From: Mark Peacock
Sent: 24 November 2016 11:41
To: Planning
Subject: FW: Northaw, The Oshwal Centre, Coopers Green Road, 16/0347/LB

From: Andrew Robley
Sent: 04 November 2016 13:02
To: Mark Peacock
Subject: FW: Northaw, The Oshwal Centre, Coopers Green Road, 16/0347/LB

From: Andrew Robley
Sent: 26 May 2016 16:58
To: Mark Peacock <m.peacock@welhat.gov.uk>
Cc: Planning <planning@welhat.gov.uk>
Subject: Northaw, The Oshwal Centre, Coopers Green Road, 16/0347/LB

DRAWING TITLE  
OSHWAL HOUSE REAR  
EXTENSION-EXISTING AND PROPOSED  
ELEVATIONS

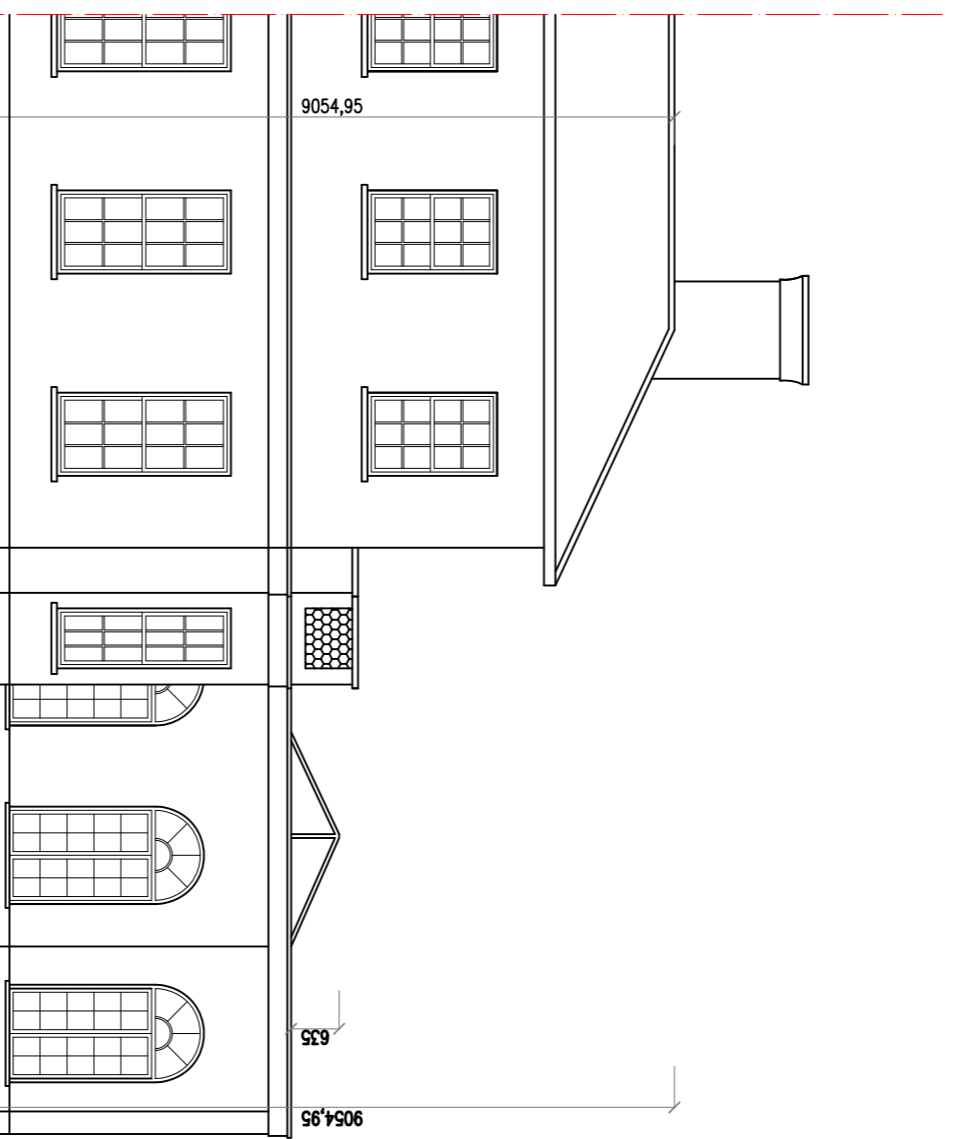
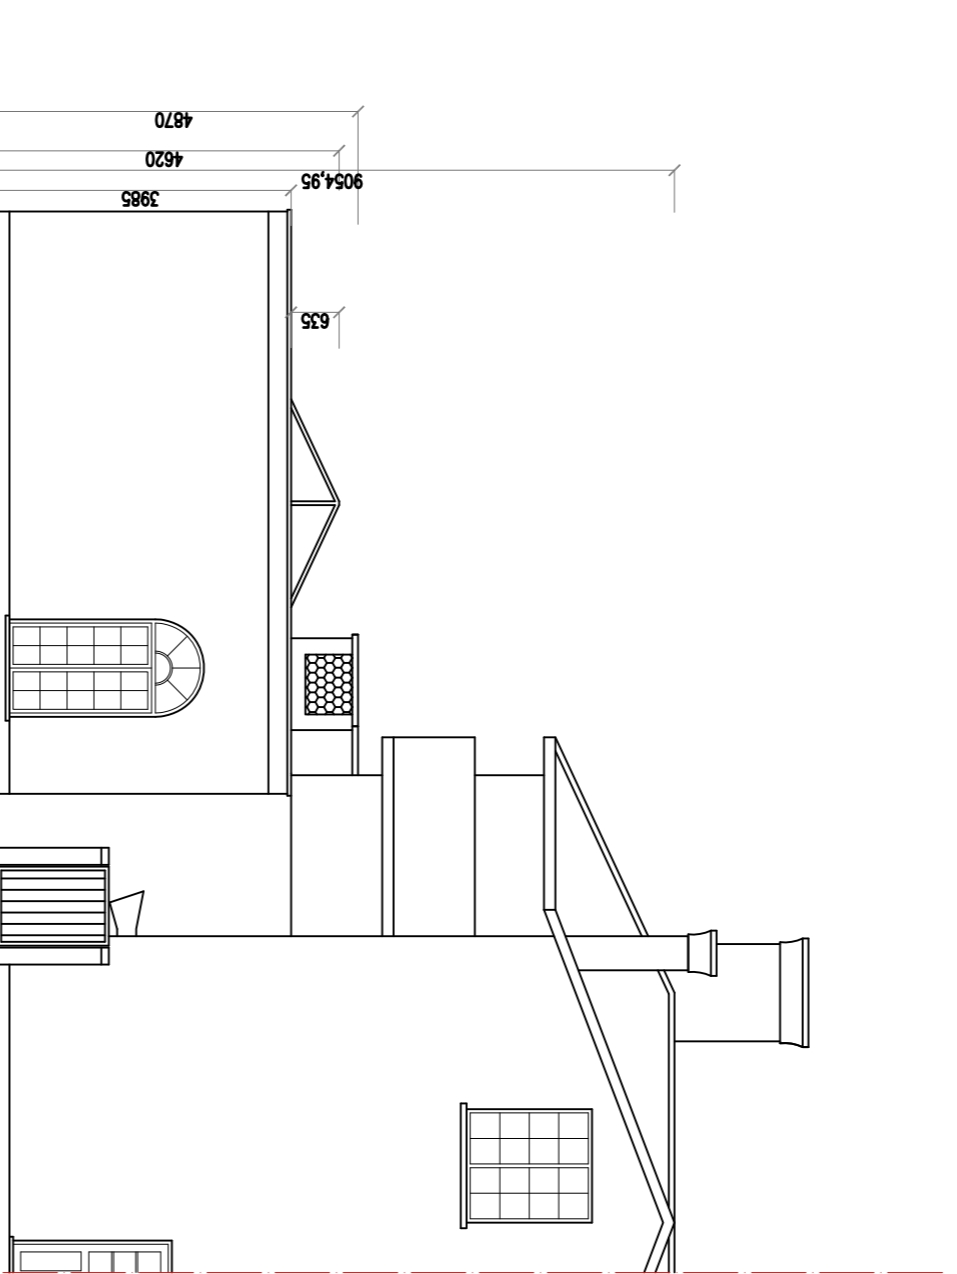
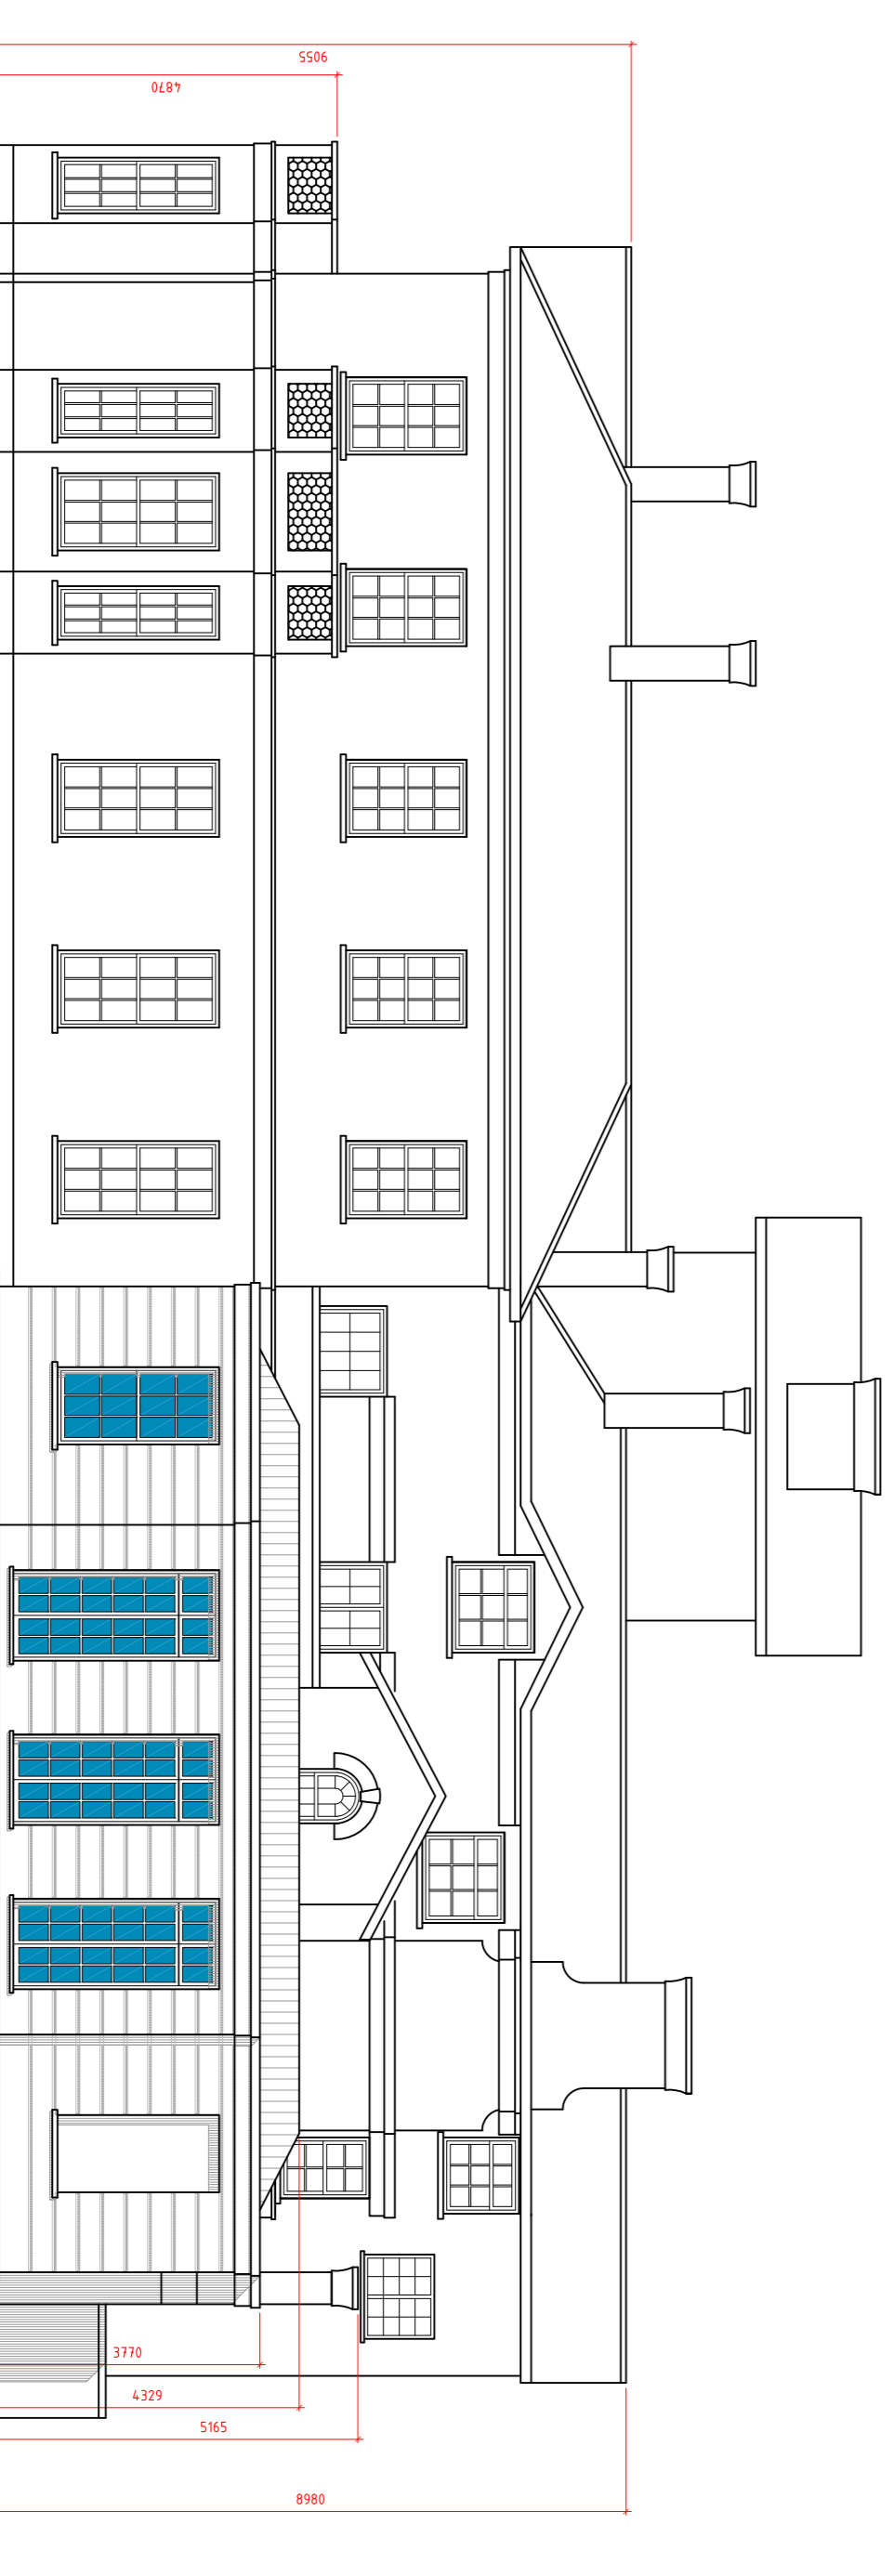
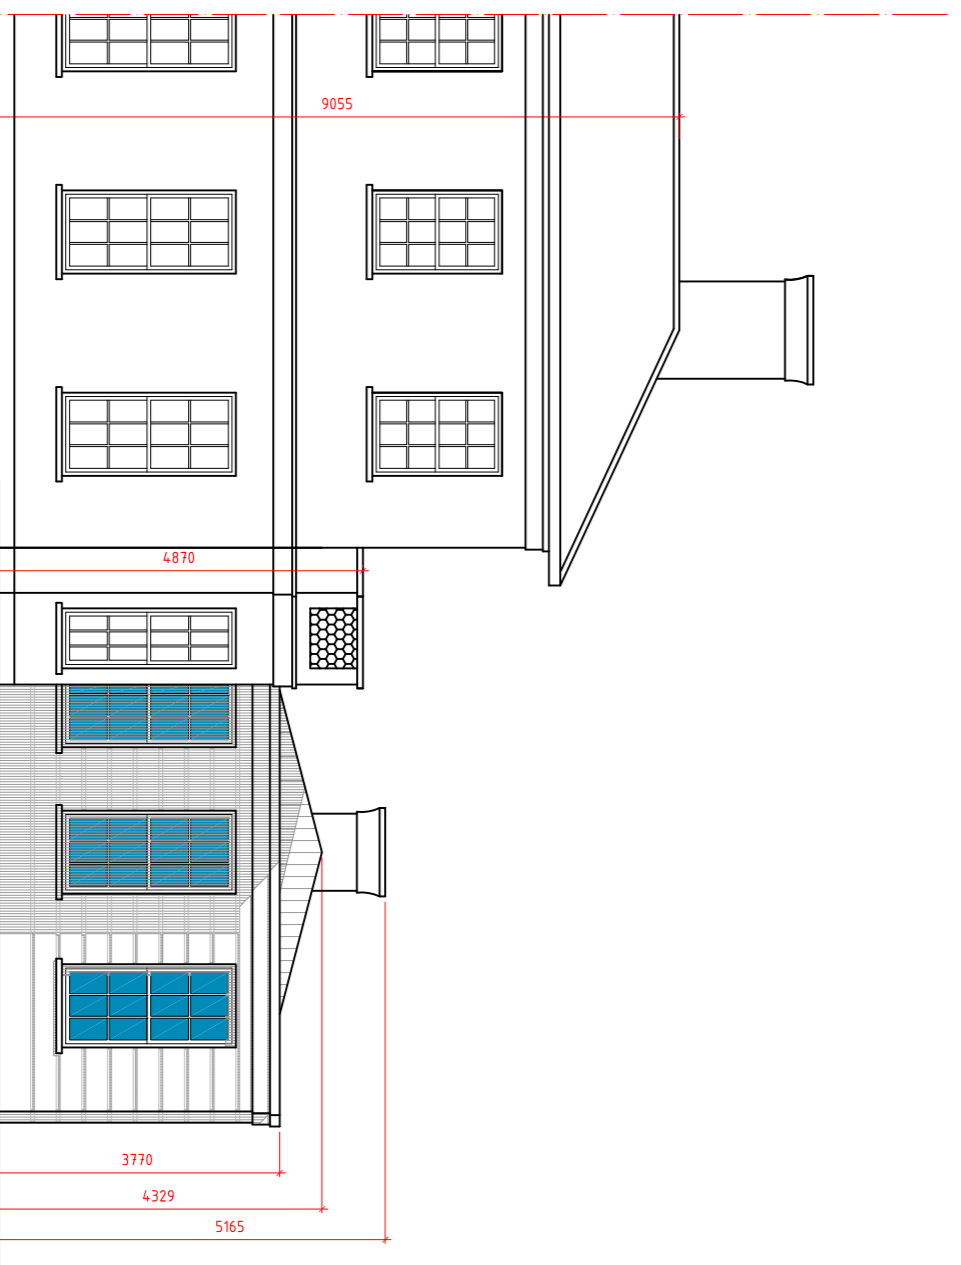
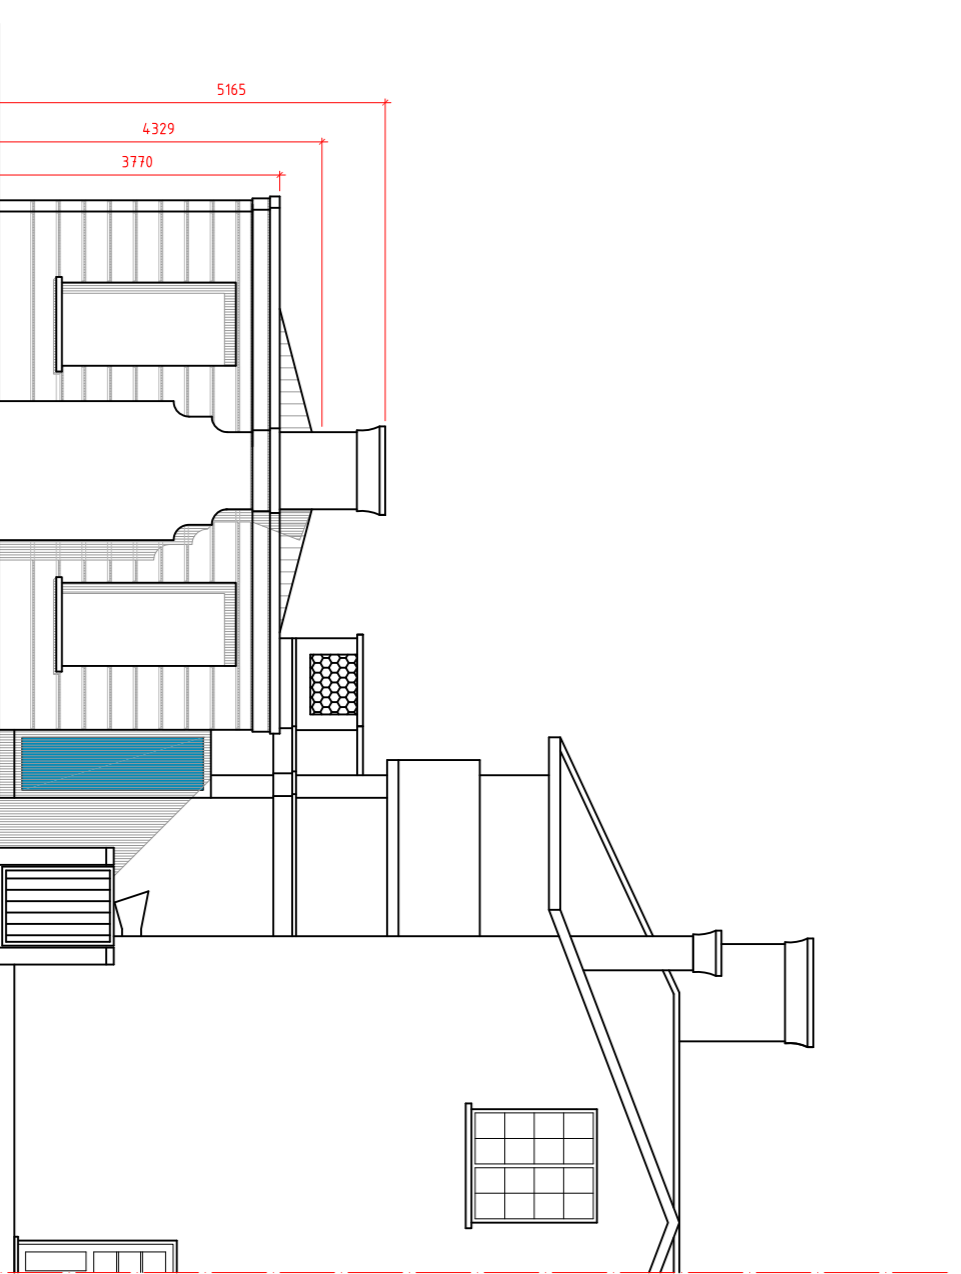
My concerns about extending the approved flat roofed extension further and covering up the whole of the rear elevation of this phase of the building remain the same.

An alternative more acceptable compromise might be to treat the extension as split level, part being in a semi-basement and therefore giving a similar number of covers. If handled well interaction between diners and volunteer kitchen staff could be acceptable.

DRAWING TITLE
 Building a new semi-permanent
 marquee connected to the Oshwal
 House

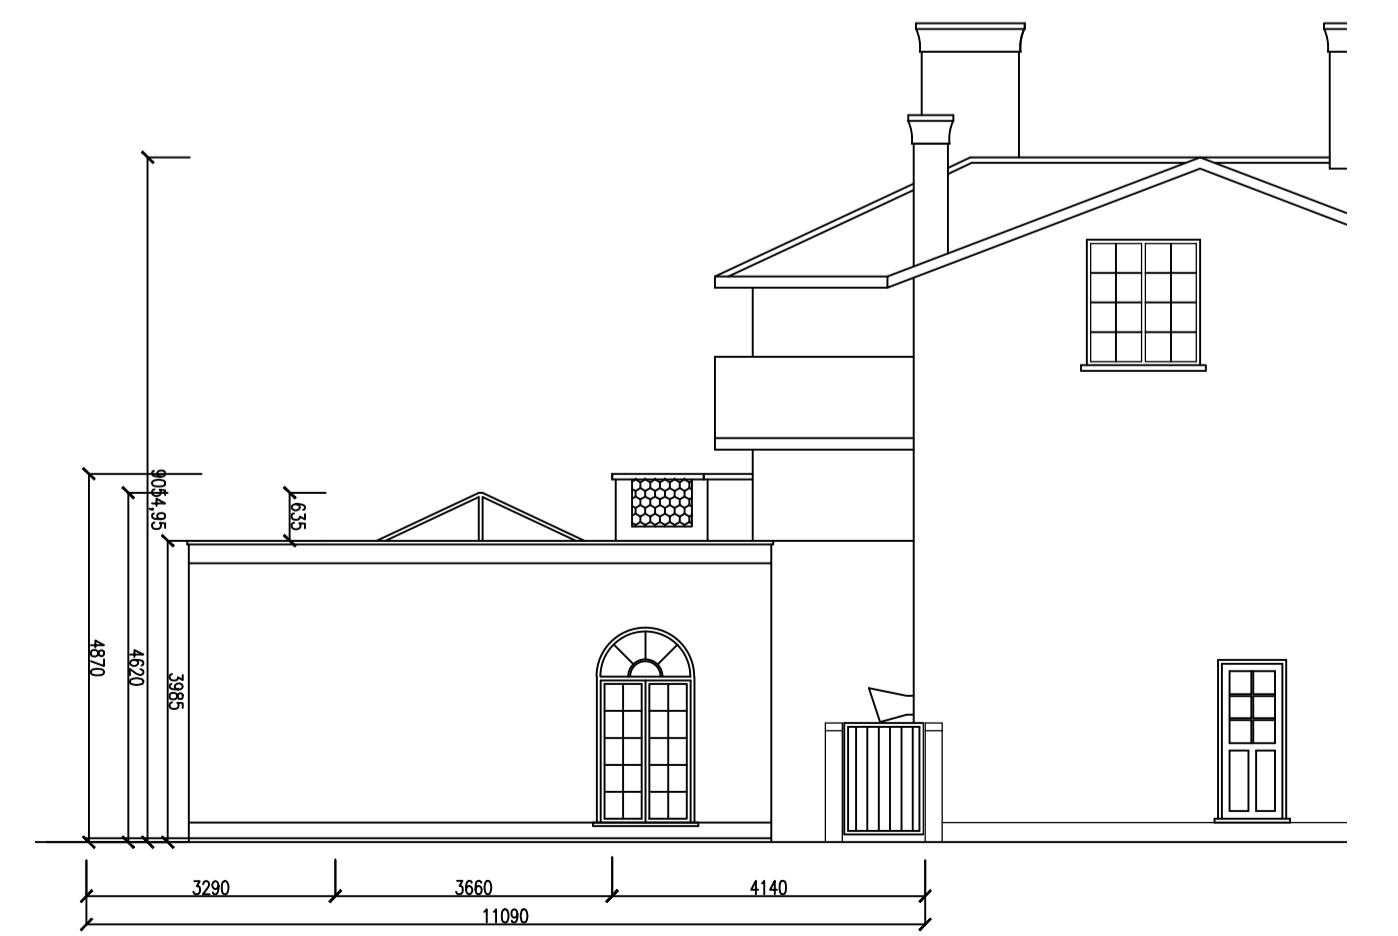
The new proposal would extend further by approximately 2.7metres making an overall extension of approximately 8.5 metres. To put this into context, this would approximately double the depth of the original west wing. The previously approved extension was allowed in this location because there had already been a modern extension at this point. However, the point was made at the time that the rear of the west wing could still be seen and therefore the “Victorian” or listed form of the building could still be appreciated.

The problem with the new proposal is that it would extend completely across the west wing and the “as listed” form of the building would become less distinguishable. Furthermore the area of flat roof , which is essentially out of character with the listed building, would be increased.

Recommendation: As it stands, the proposal would extend too far and would cover up the remainder of the ground floor of the west wing. It would therefore harm the character and appearance of the listed building and its setting, would not now be sufficiently balanced by the community benefit and would not conform to the NPPF 2012 paras 7, 8, 9 , 131, 132, 134 and the Local Plan D1, D2, R25.

Further Advice: A large extension was previously approved and it is felt that the perceived form should not extend further than this. It is recommended that the applicant looks at the possibility of housing the kitchens in a basement under the approved extension which would free up more dining space.
